From: Laura Gibbons <Laura.Gibbons@arun.gov.uk>
Sent: 08 February 2022 10:51
To: Planning.Responses <Planning.Responses@arun.gov.uk>
Cc: Simon Davis <Simon.Davis@arun.gov.uk>
Subject: RE: Planning Consultation on: AW/18/22/DOC

Engineers Comments Regarding Condition 4

Application No: AW/18/22/DOC

Description of Works: Approval of details reserved by condition imposed under AW/130/18/OUT relating to conditions 4-surface water drainage, 5-drainage flows, 6 - maintenance and management of surface water drainage system & 7-arrangement for the future access and maintenance of watercourses.

PROJECT	DEVELOPMENT TO REAR OF 34-44 CARLTON AVENUE BOGNOR REGIS, W SUSSEX PO21 3LR		
DRAWING	PROPOSED IMPERMEABLE AREAS & SUMMARY GEOTECH DATA		
SCALE	FC2891/11	REV	A
1:250	DATE	JUNE 21	MH
	INITIAL	CHD	-

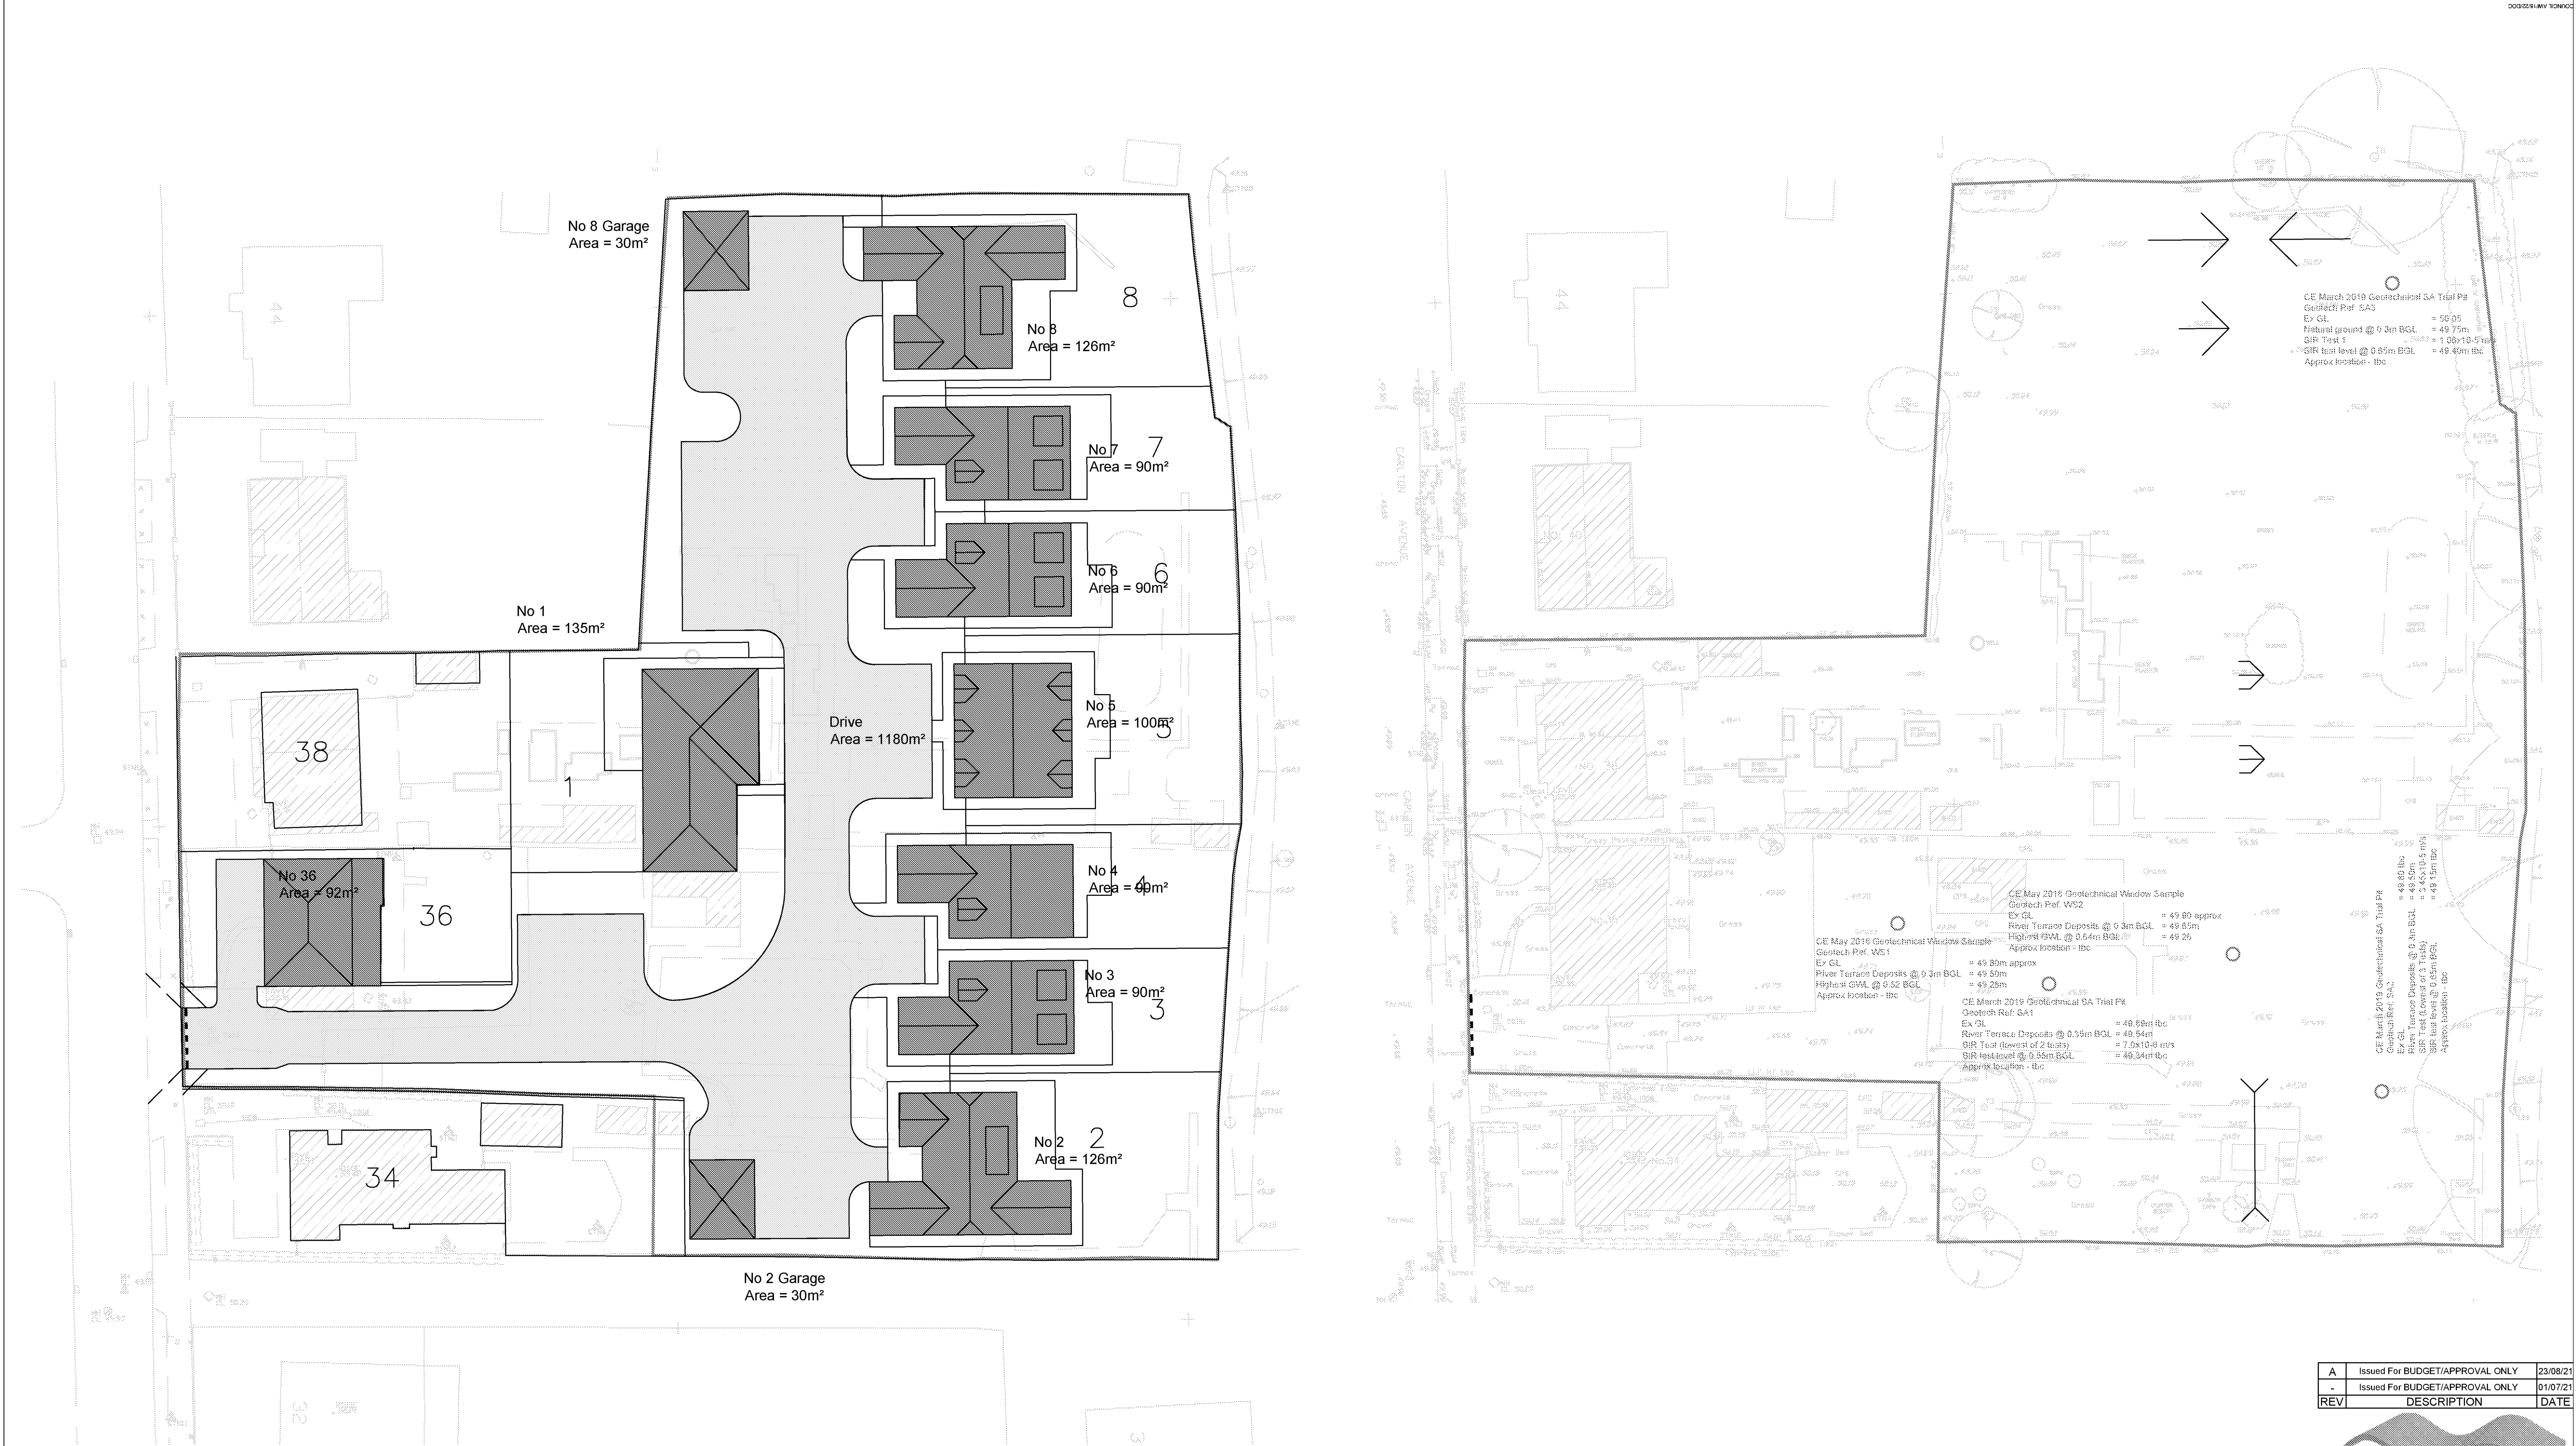
Please detail pipe diameters and falls.

Please detail invert levels of diffusers.
